National Highways Planning Response (NHPR 21-09) Formal Recommendation to an Application for Planning Permission

Council's Reference: 21/03268/OUT

Location: OS Parcel 2636, NW of Baynards House, Ardley

National Highways Ref: 92859

Drawing Number  
**S1299-P-12**

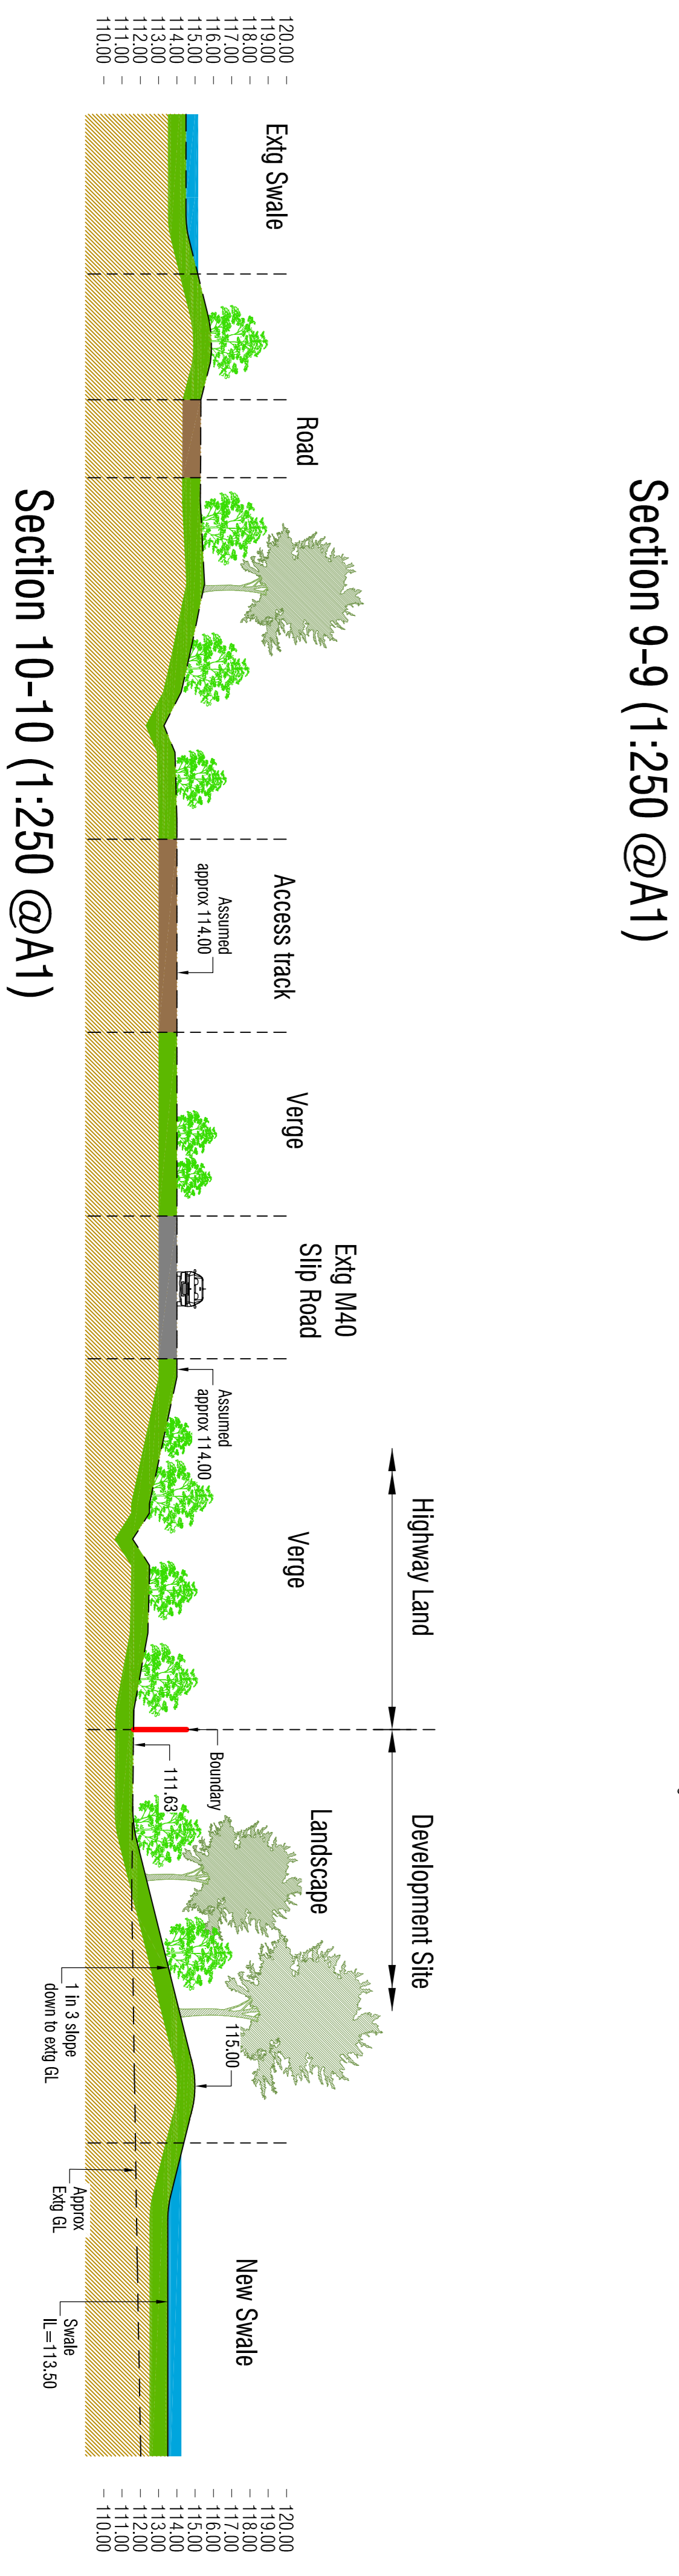
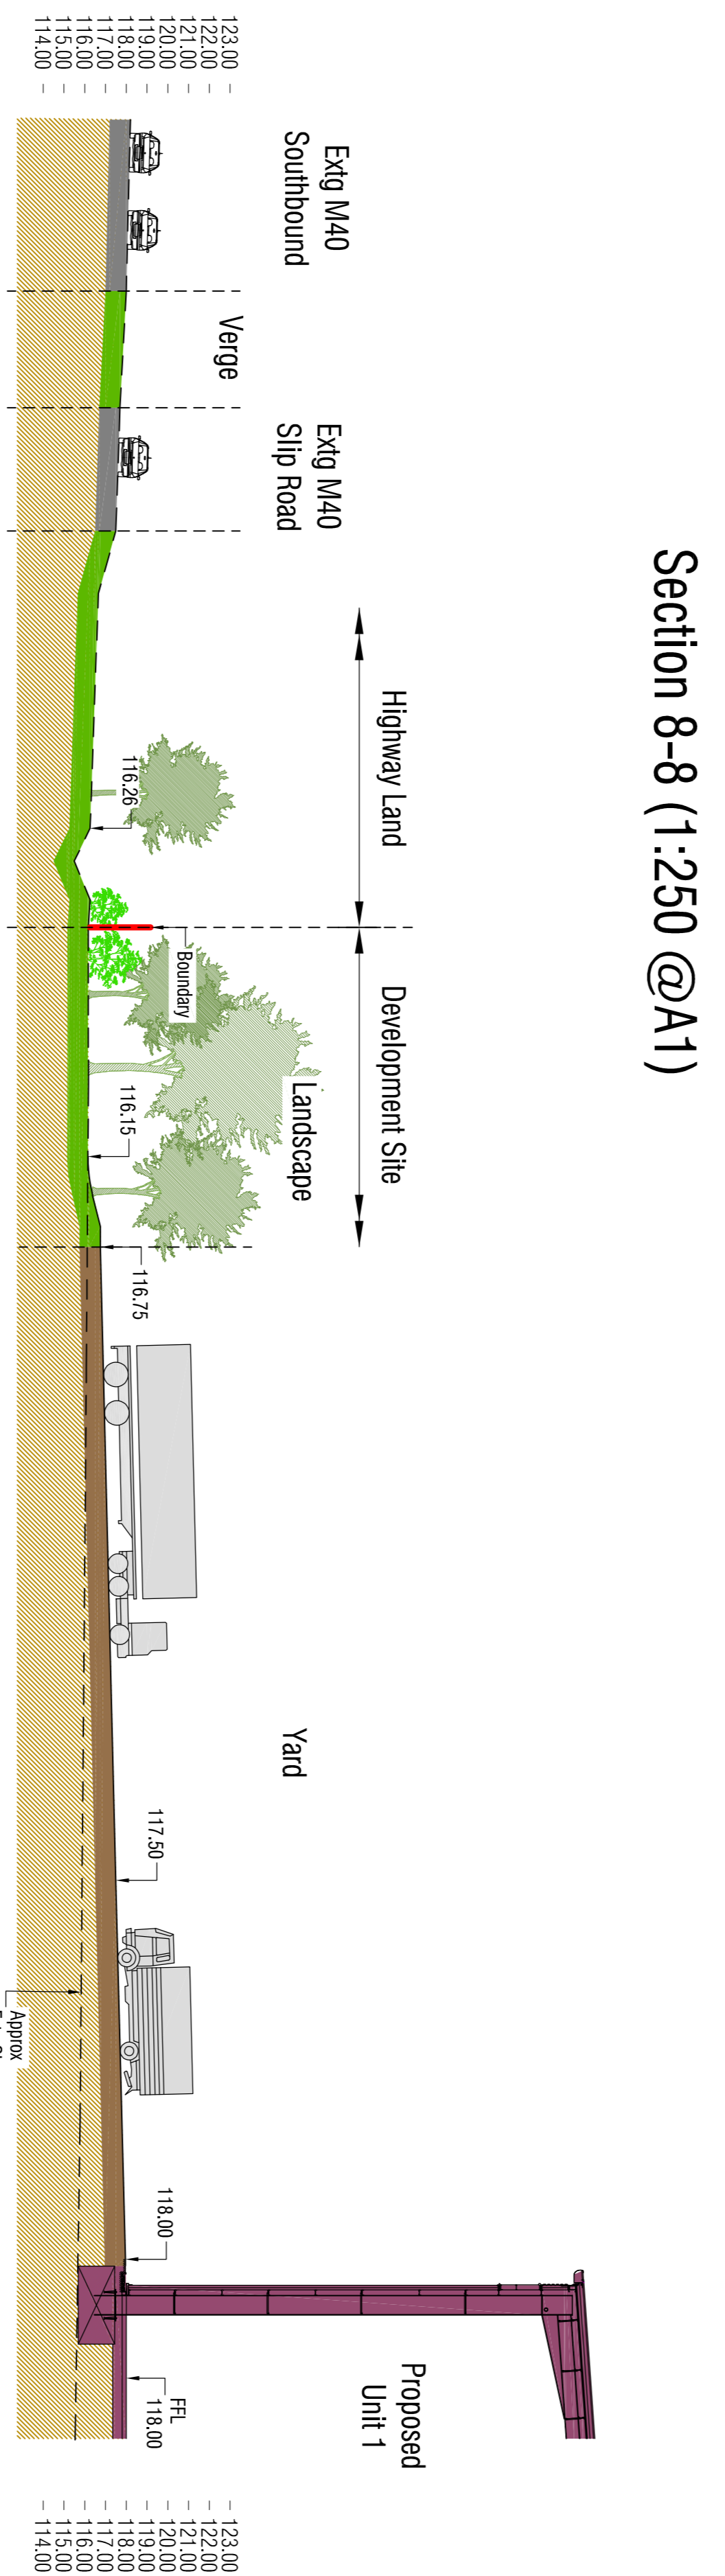
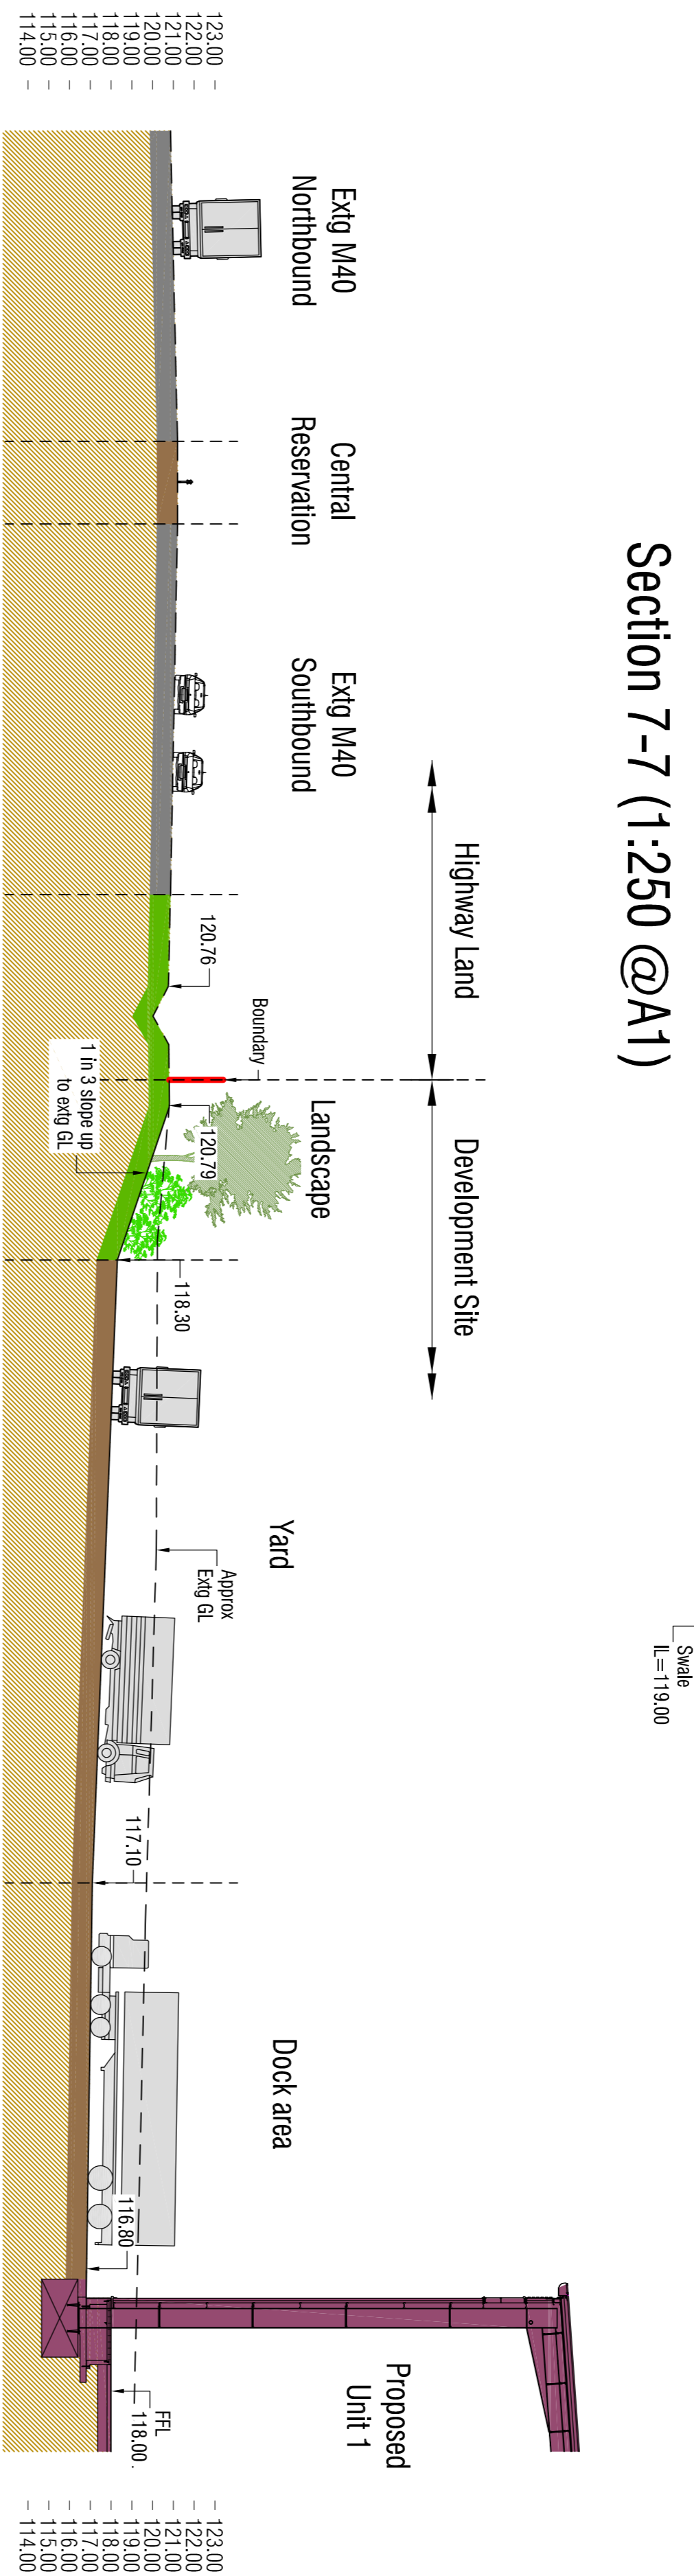
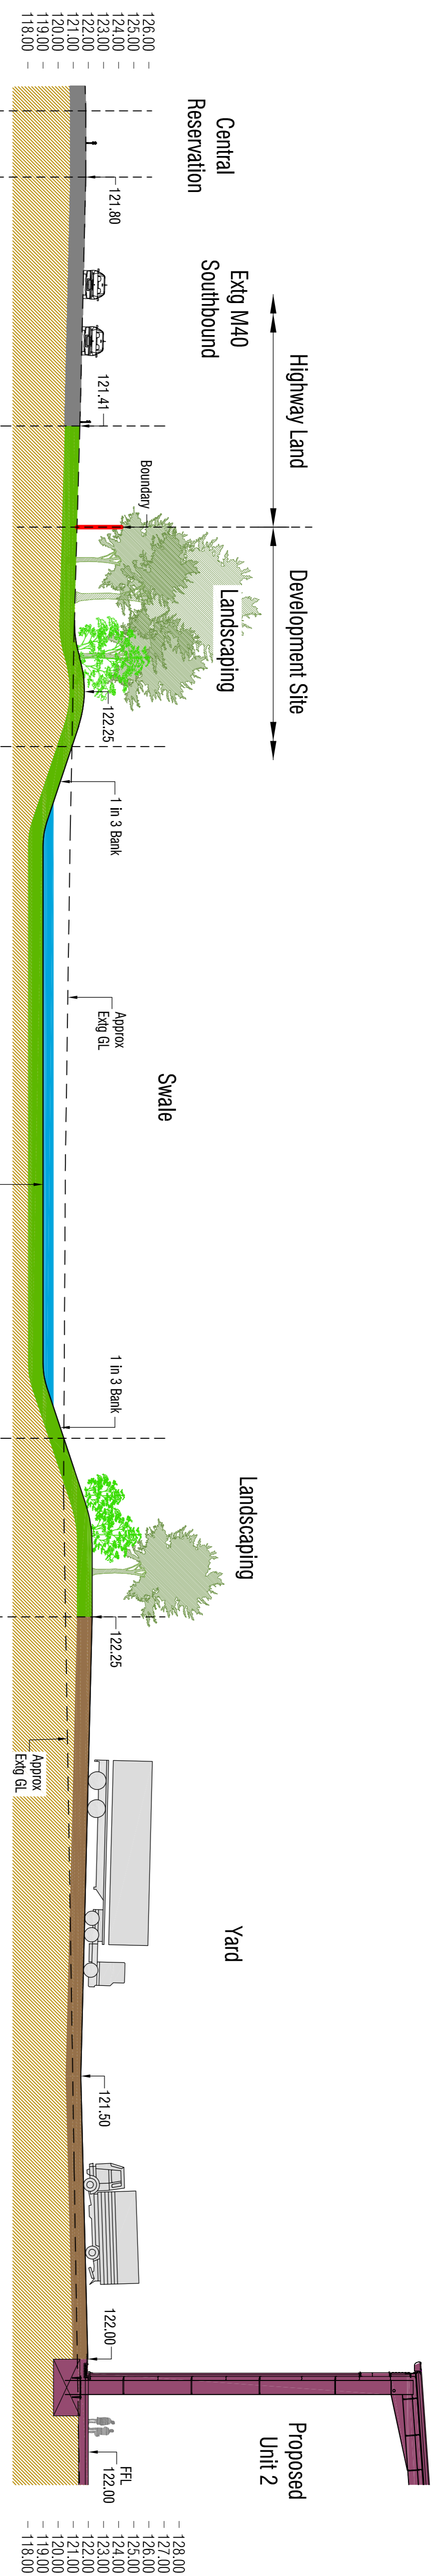
The applicant will need to advise / confirm if there will be any earthworks associated with the development(s) in relatively close proximity to National Highways boundaries

(e.g. the stability of the balancing ponds, etc). In the first instance, some cross sections (to scale) through the boundaries showing the proposed extent of the development, its features and any proposed changes in elevation (excavations, landscaping) etc should be submitted for further assessment. Once received, we will review to determine the possible extent of any geotechnical reporting under the Design Manual for Roads and Bridges (DMRB) standard CD 622, which may be required to confirm the extent of any geotechnical risk to the SRN.
